<b>REQUEST</b>	Current Zoning: I-2, general industrial Proposed Zoning: UR-3(CD), urban residential conditional
<b>LOCATION</b>	Approximately 15.99 acres located on the east side of Matheson Avenue between N. Tryon Street and the Southern Railway railroad
<b>CENTER, CORRIDOR OR WEDGE</b>	Corridor
<b>SUMMARY OF PETITION</b>	Proposal to rezone property to accommodate the construction of up to 327 attached townhomes and flats, and an option to add ground floor office and retail up to 44,000 square feet. The original site plan submitted as part of this petition proposed the construction of 163 townhomes and flats. The revised site plan doubles the proposed number of residential units at a density of 20.45 units per acre.
<b>STAFF RECCOMENDATION</b>	The petitioner has worked with staff to address several site design and site plan issues. However, the petitioner must choose one of two proposed development options. Staff recommends approval of this request subject to the petitioner addressing outstanding issues.

**PLANNING STAFF REVIEW**

MATHESON AVENUE/30th STREET
 CHICK GODLEY RD. AND DRIVEWAY ACCESS PLAN
TECHNICAL DATA SHEET NOTES
 PETITION NO. 2008-082

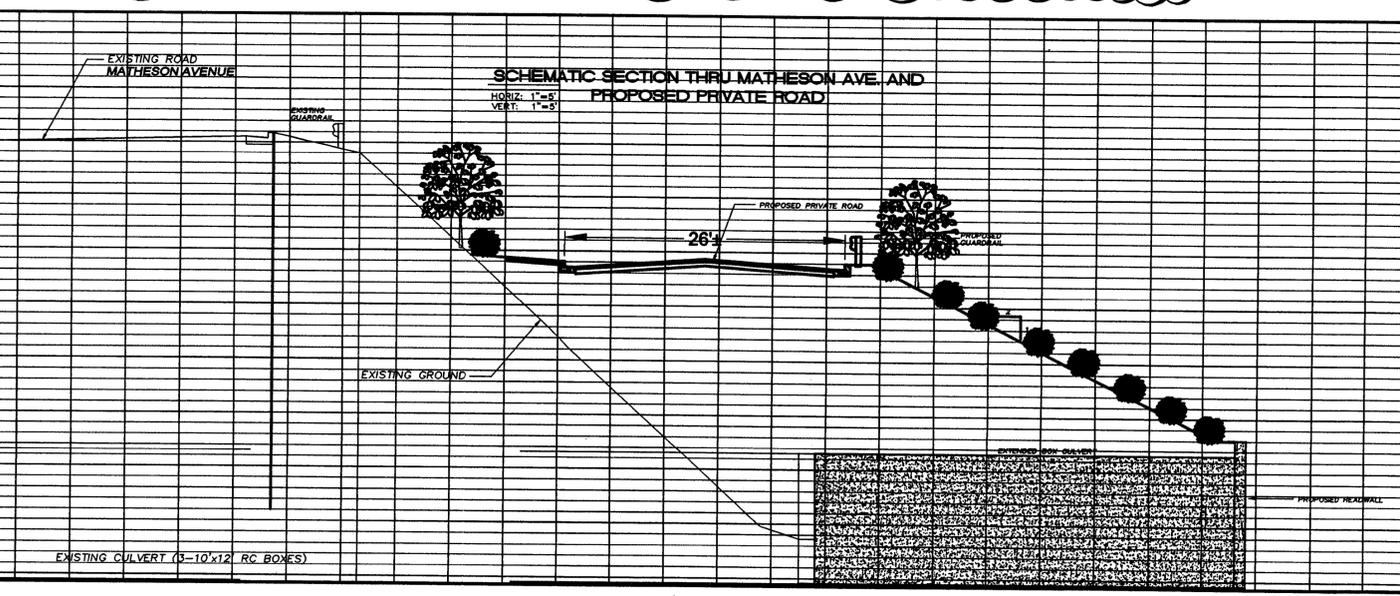
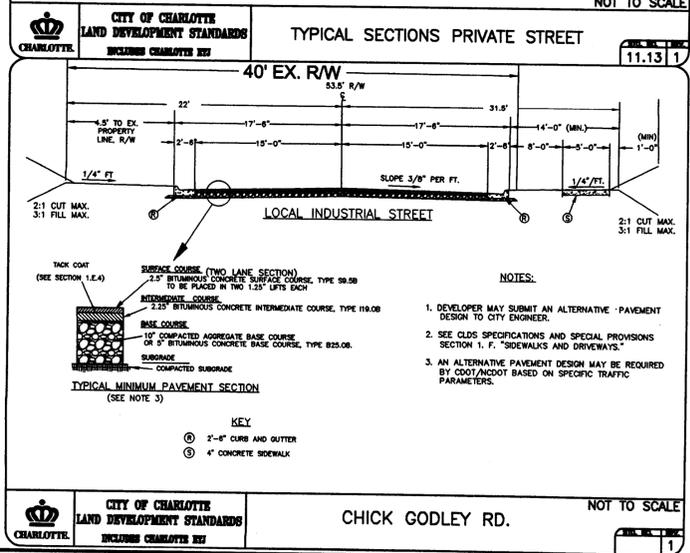
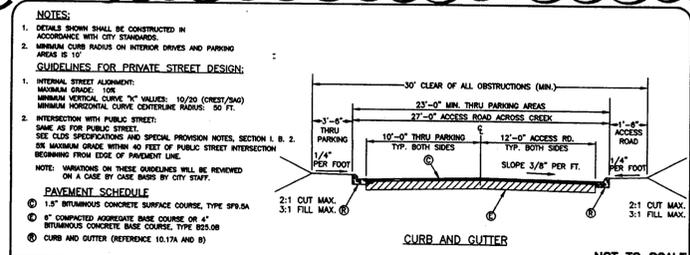
1. The site plan currently proposes two (2) development options. The petitioner should amend the site plan to reflect only one (1) development option.
2. Conditional Note #17 on Sheet 2 of the site plan notes proposes that Unit 13 contain 1,000 sq. ft. of retail/office, Units 1-6 and 8-12 contain 4,000 square feet in each building, and Unit 7 contain 3,000 square feet. Based upon the above, the amount of retail/office proposed is 48,000 square feet and exceeds the maximum 44,000 square feet identified on the site plan. The petitioner should correct this information on the site plan.
